From: [Rodenbeck, Jay B.](#)
To: [Aranda, James M.](#)
Cc: [Webb, Robert L.](#)
Subject: FW: New AA @ 6901 San Antonio - PR-2023-008275 / SI-2023-00404 (Grace Church)
Date: Thursday, April 20, 2023 5:38:00 PM

Grace Church -- 6901 San Antonio --

Adding new food truck court in NE portion of back lot.

The Project # is: PR-2023-008275

February 2, 2023  
ADDITION OF MOBILE FOOD  
TRUCK COURT

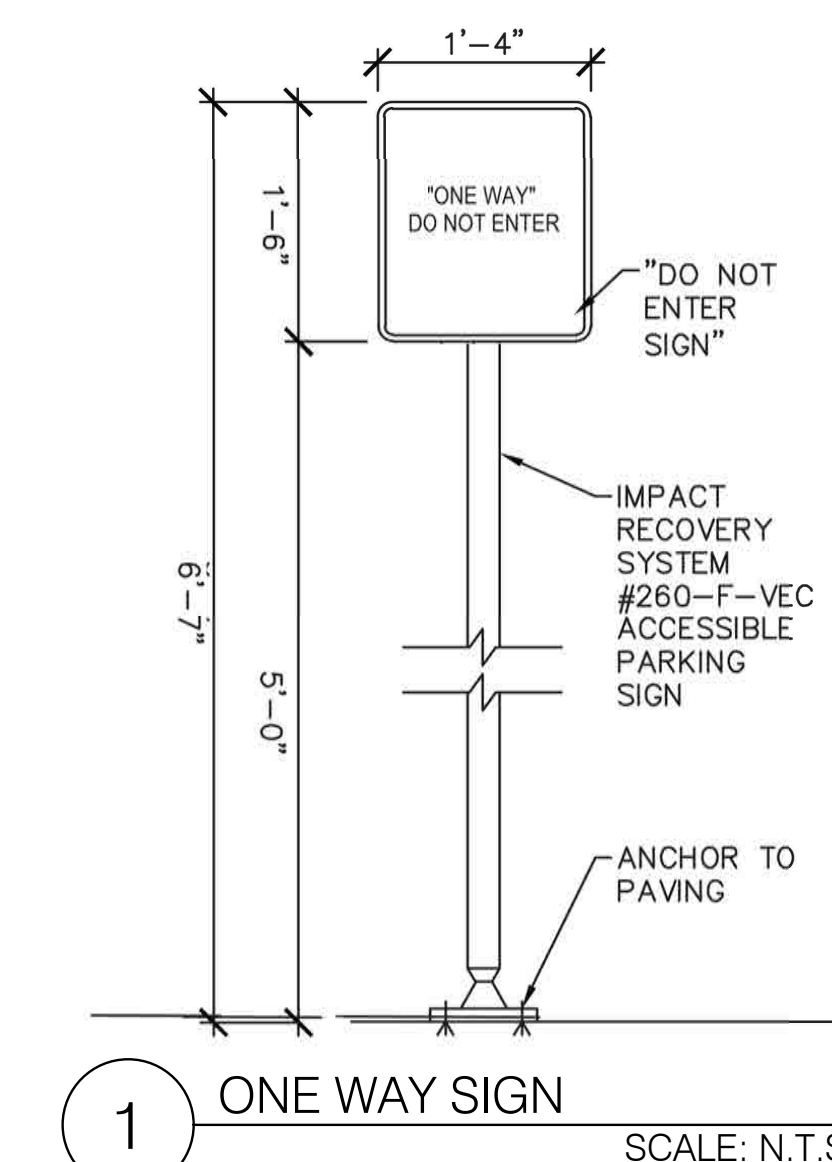
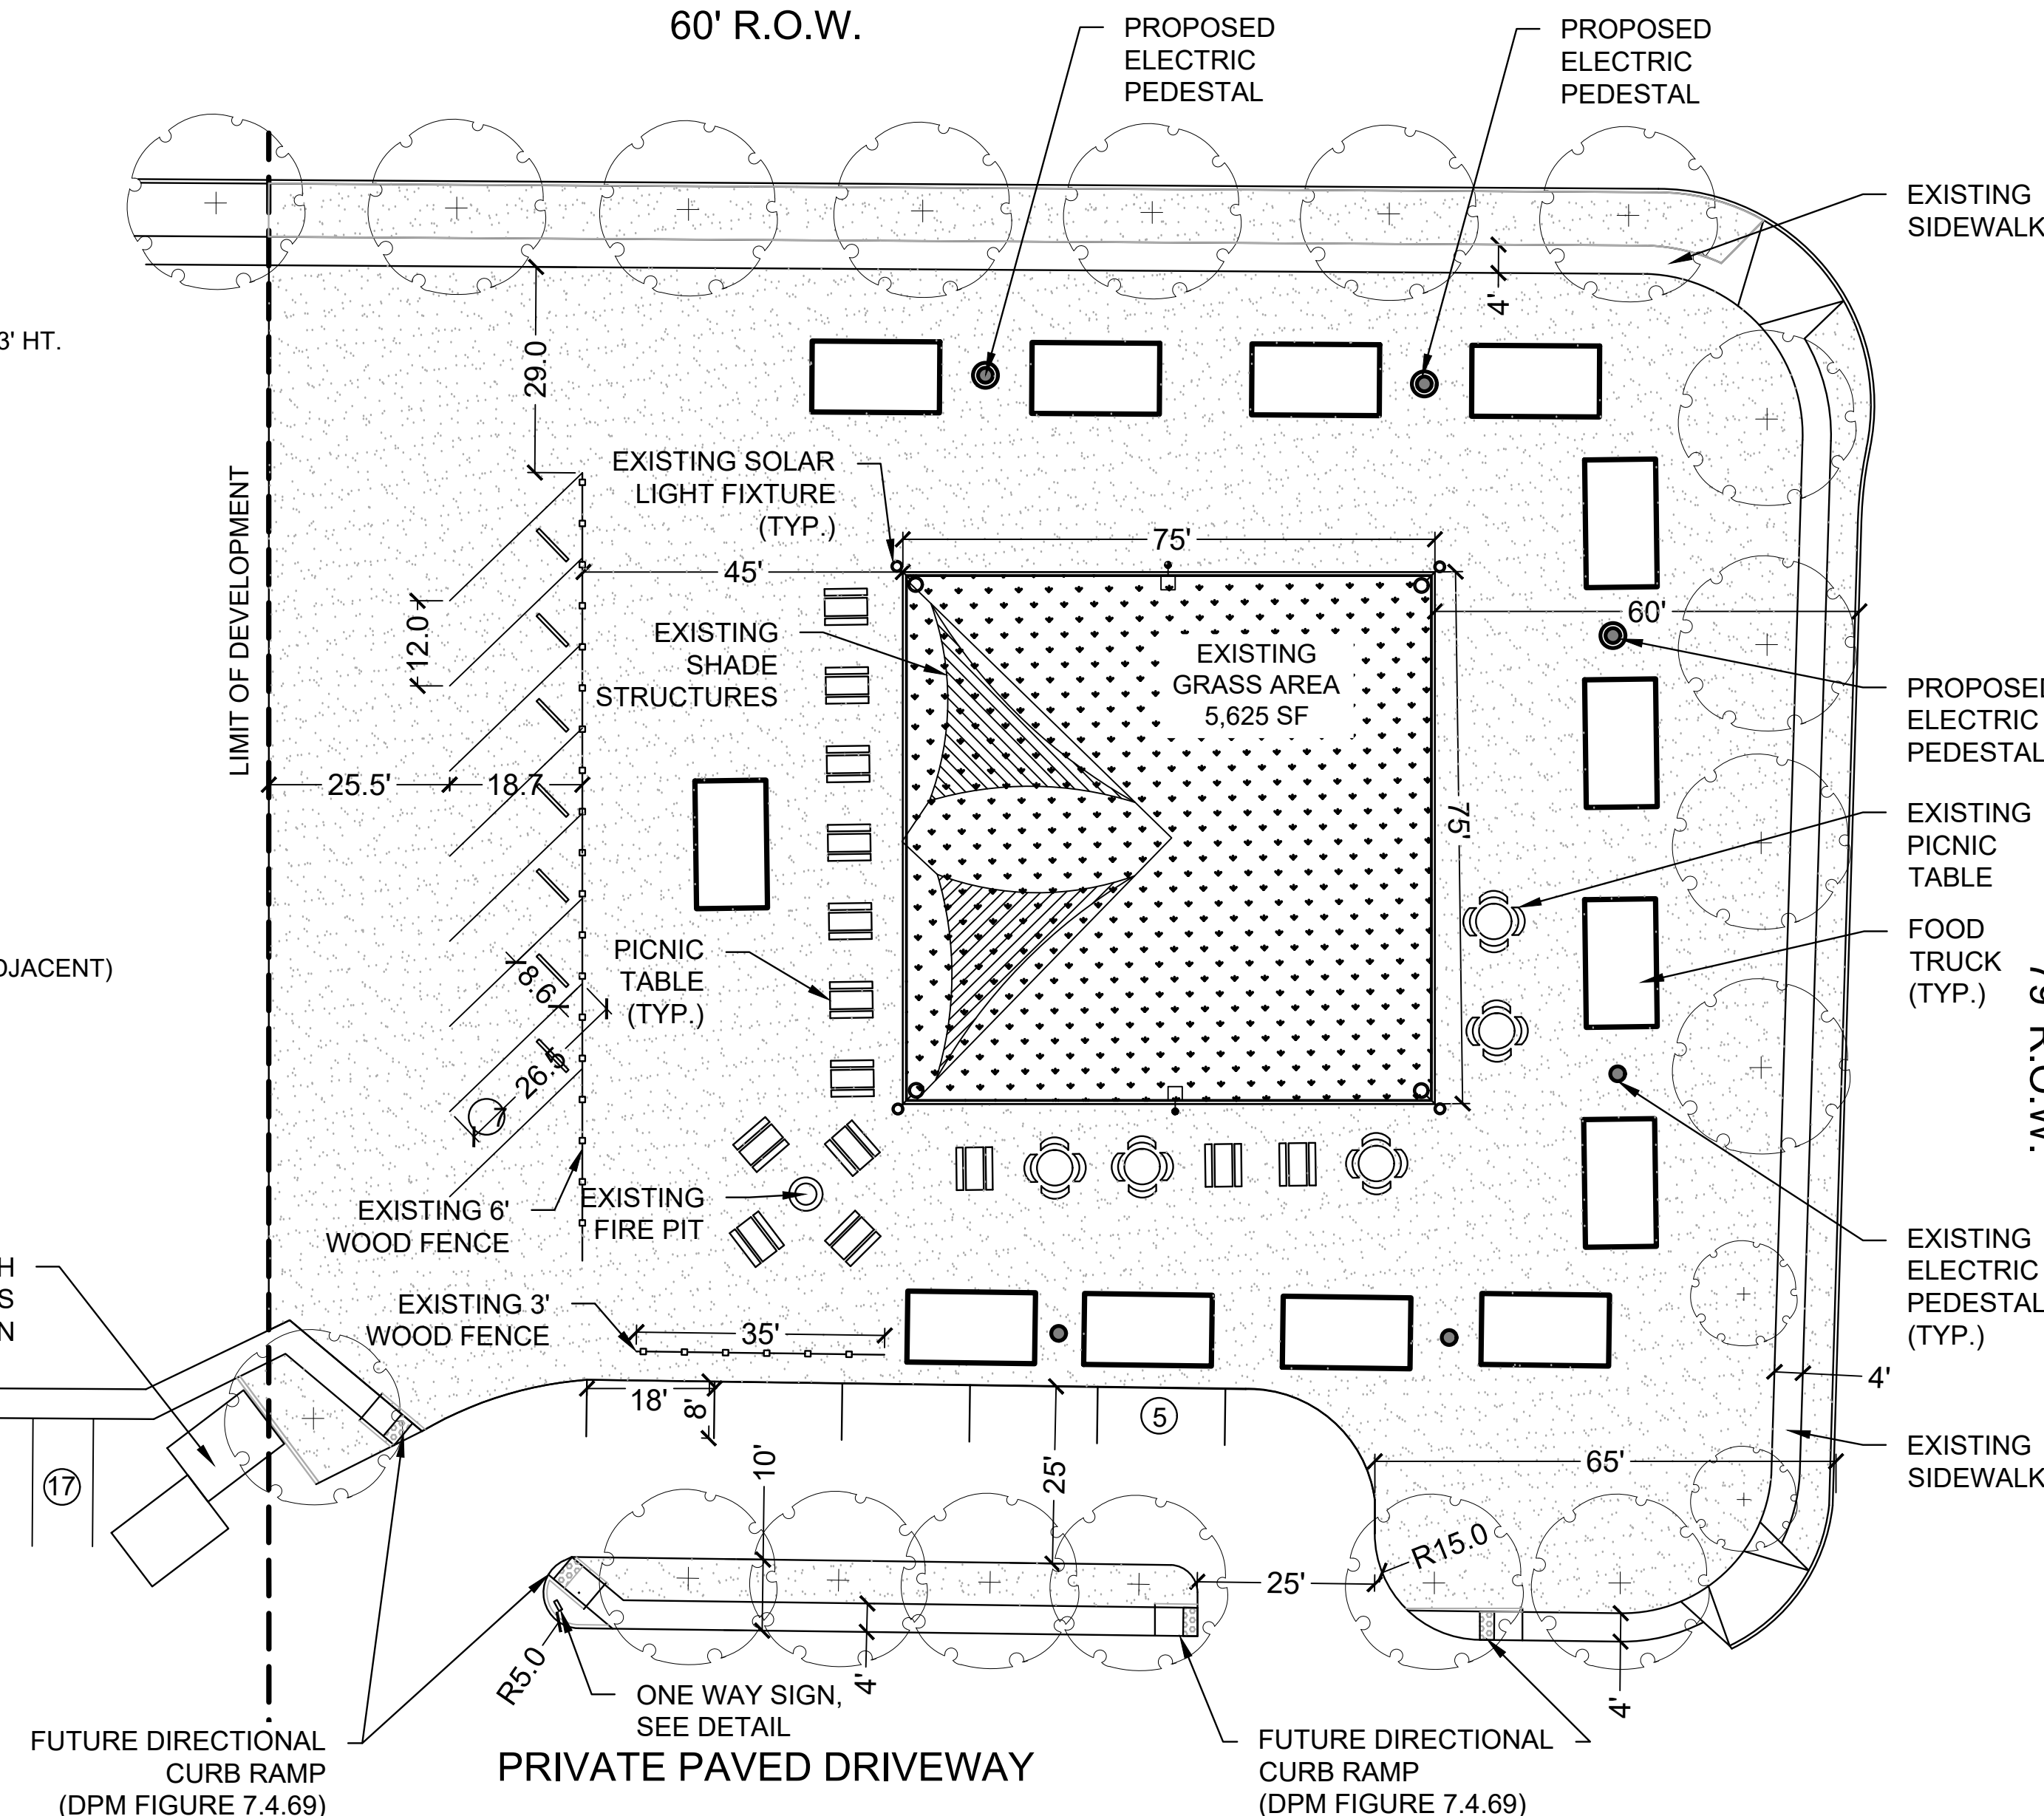
Lot has crusher-fine rock with grass area in middle.

Provided updated calculations.

Parking and landscaping is meeting.

*Recommend planning/zoning approval.
